Application for a non-material amendment following a grant of planning permission. Town and Country Planning Act 1990

ERECTOR OF 2 DWELLINGS AND ASSOCIATED WORKS
AT BRYN TIRION, SALE LANE, TREWERN.

P | 2018 | 0225

ADDITION OF WINDOW TO MASTER BEDROOMS TO MEET
FIRE ESCAPE REQUIREMENTS IN COMPLIANCE WITH
BUILDING REGS - PART B.
AND REMOVAL OF 4 NO VELUX WINDOWS

PROJECT NO. <b>D21/03</b>	DRAWING NO. <b>004</b>	REVISION <b>B</b>
------------------------------	---------------------------	----------------------

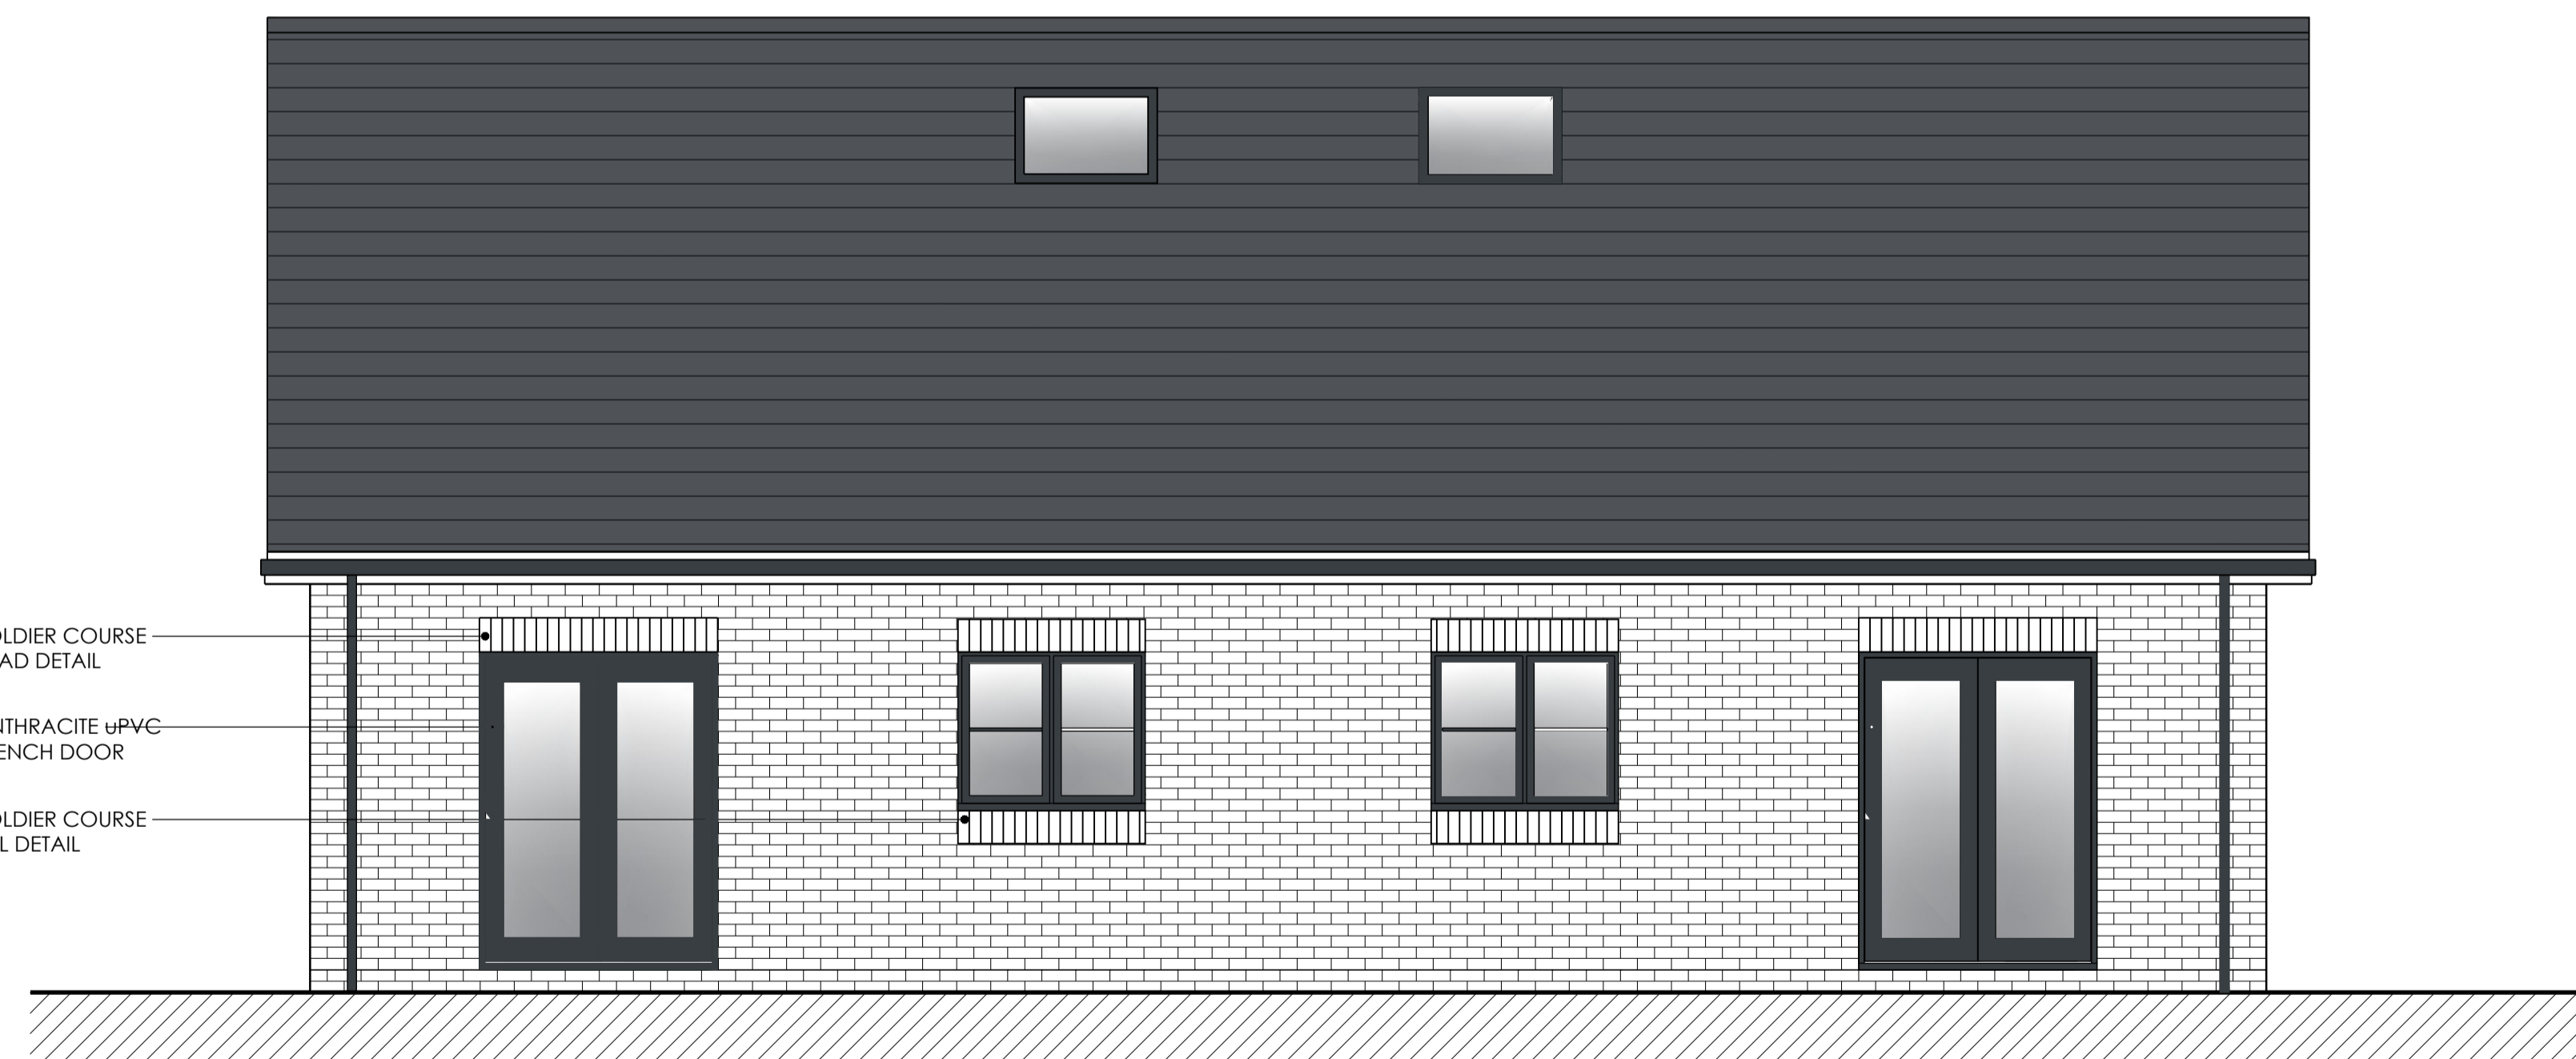
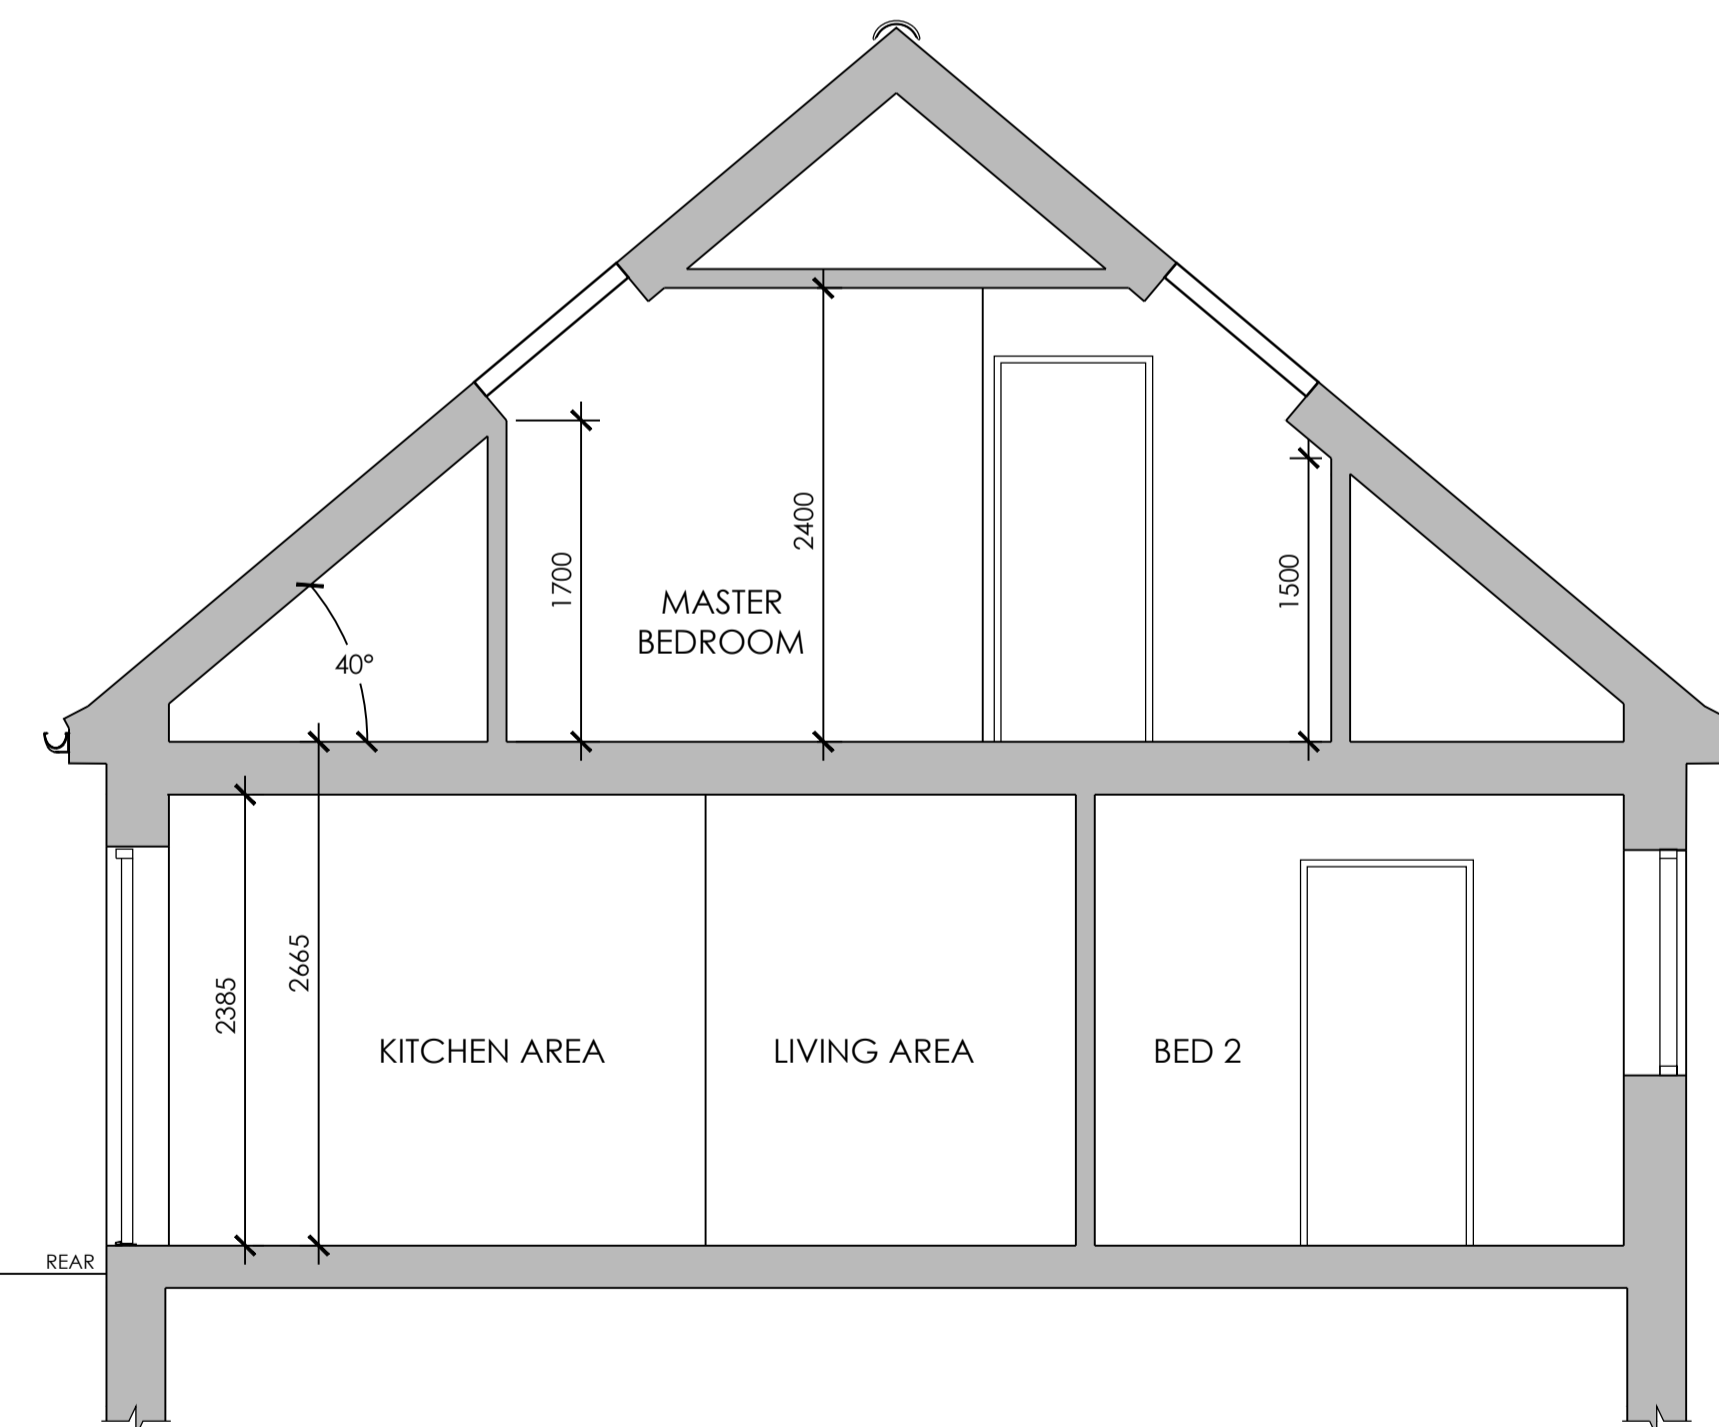
TO COMPLY WITH BUILDING REGS PART B

PROJECT NO. <b>D21/03</b>	DRAWING NO. <b>003</b>	REVISION <b>B</b>
------------------------------	---------------------------	----------------------

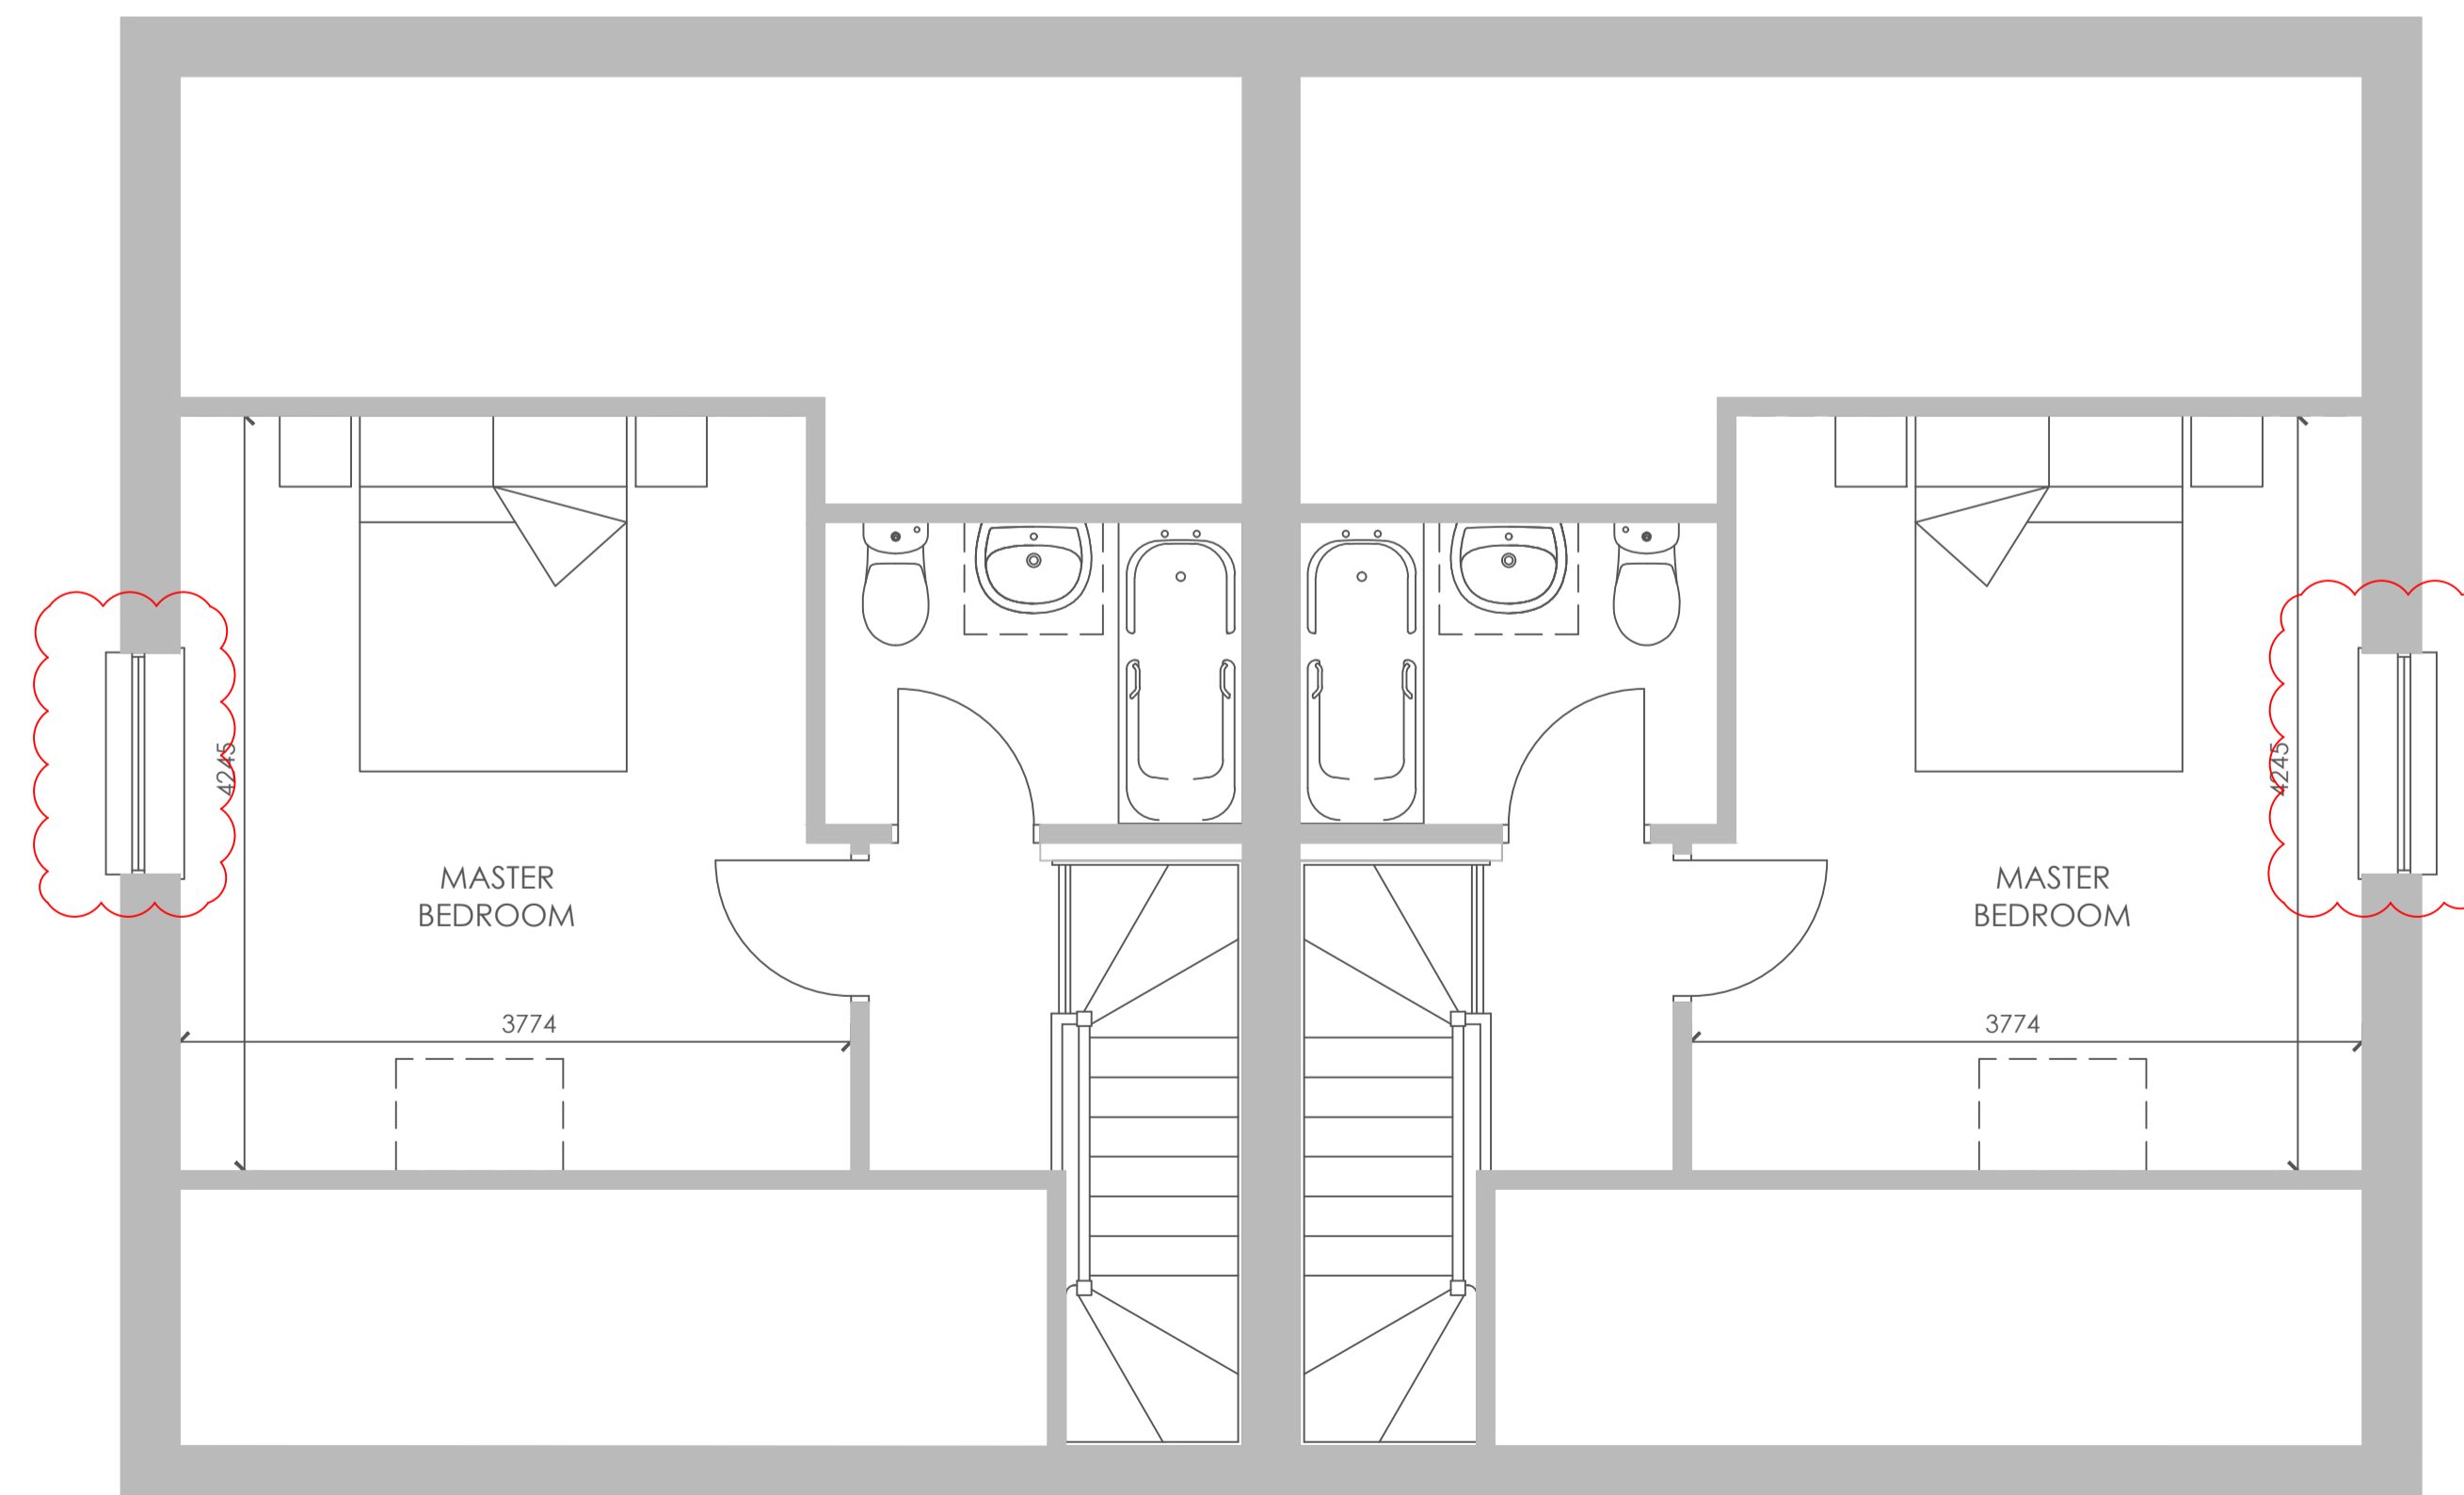
D21/03 003 B
